Application Ref:	3/2026/0374	 Ribble Valley Borough Council www.ribblevalley.gov.uk
Date Inspected:	N/A	
Officer:	BT	
DELEGATED ITEM FILE REPORT:		NON-MATERIAL AMENDMENT

Application Description:	Non-material amendment to planning permission 3/2022/0966 involving amendments to external materials and windows to rear elevations of dairy building conversion and garden room, amendment to external materials and door position to ancillary building conversion, minor re-positioning and external materials amendments to garage to rear of dairy building conversion.
Site Address/Location:	Crow Trees Farm, Crow Trees Brow, Chatburn, BB7 4AA.

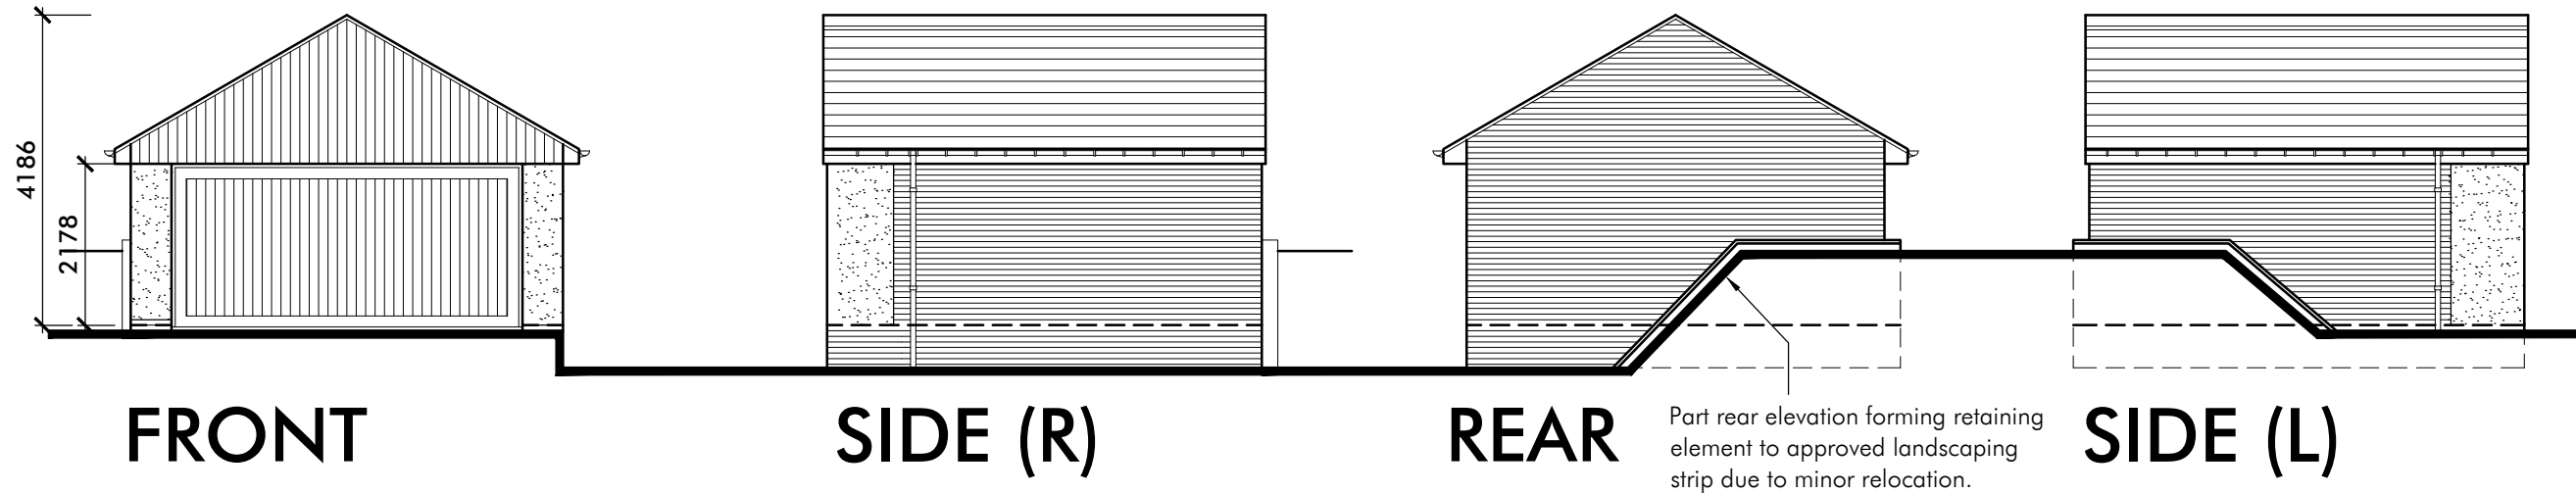
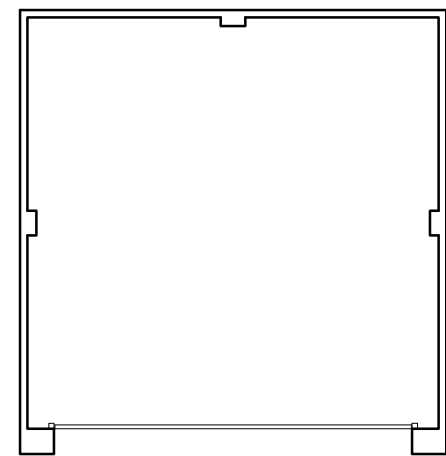
Furthermore, the proposal seeks to predominantly utilise smooth blue brickwork for the side and rear profiles of the detached garage building (along with some smaller sections of white chalk render) which again would be noticeably in contrast to the predominantly vertically cladded design as originally approved.

Taking account of the above, it is considered that the amendments proposed amount to a development that would be materially different in terms of design and external appearance to that of the original consent.

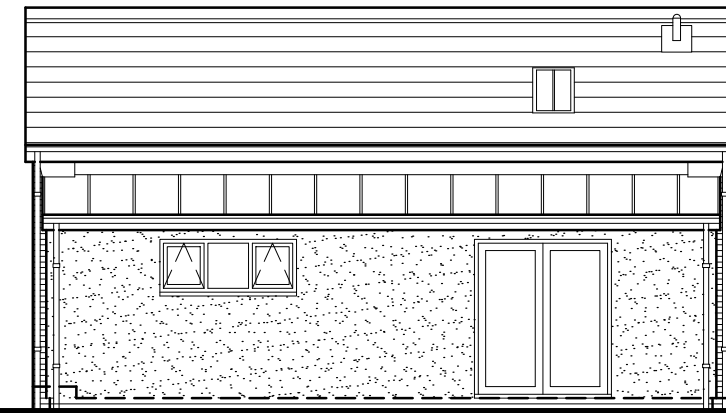
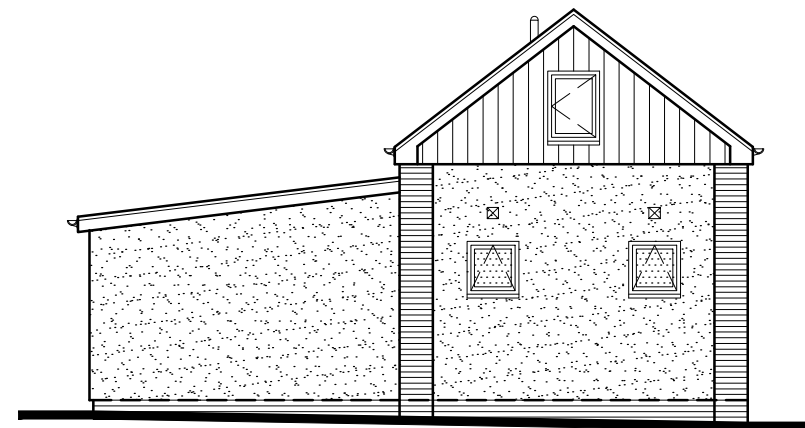
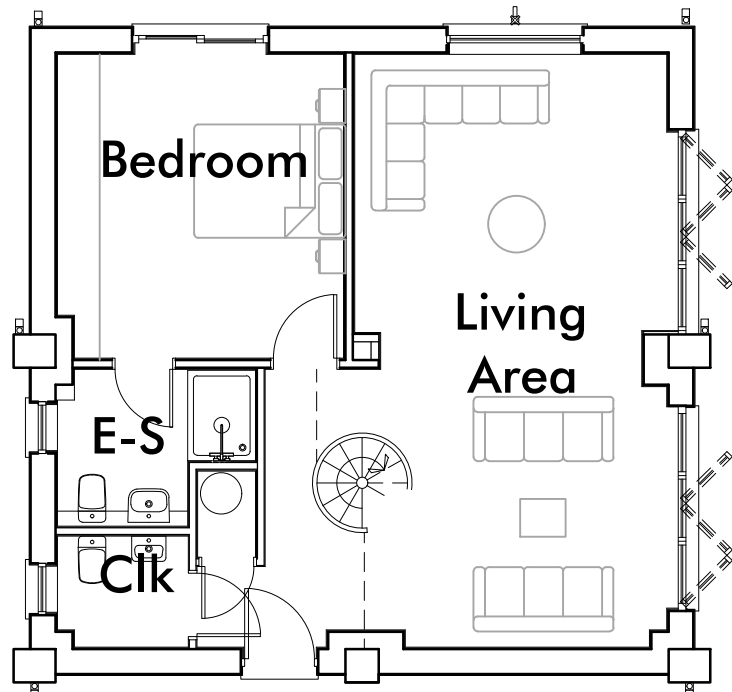
In a similar vein, whilst the reconfigured door position within the front elevation of the Dutch barn building would amount to a non-material visual change in the context of the originally approved design, the proposal seeks to predominantly utilise white chalk render for the elevational profiles of this building which would also result in a perceivable visual change relative to the cladded design as originally approved.
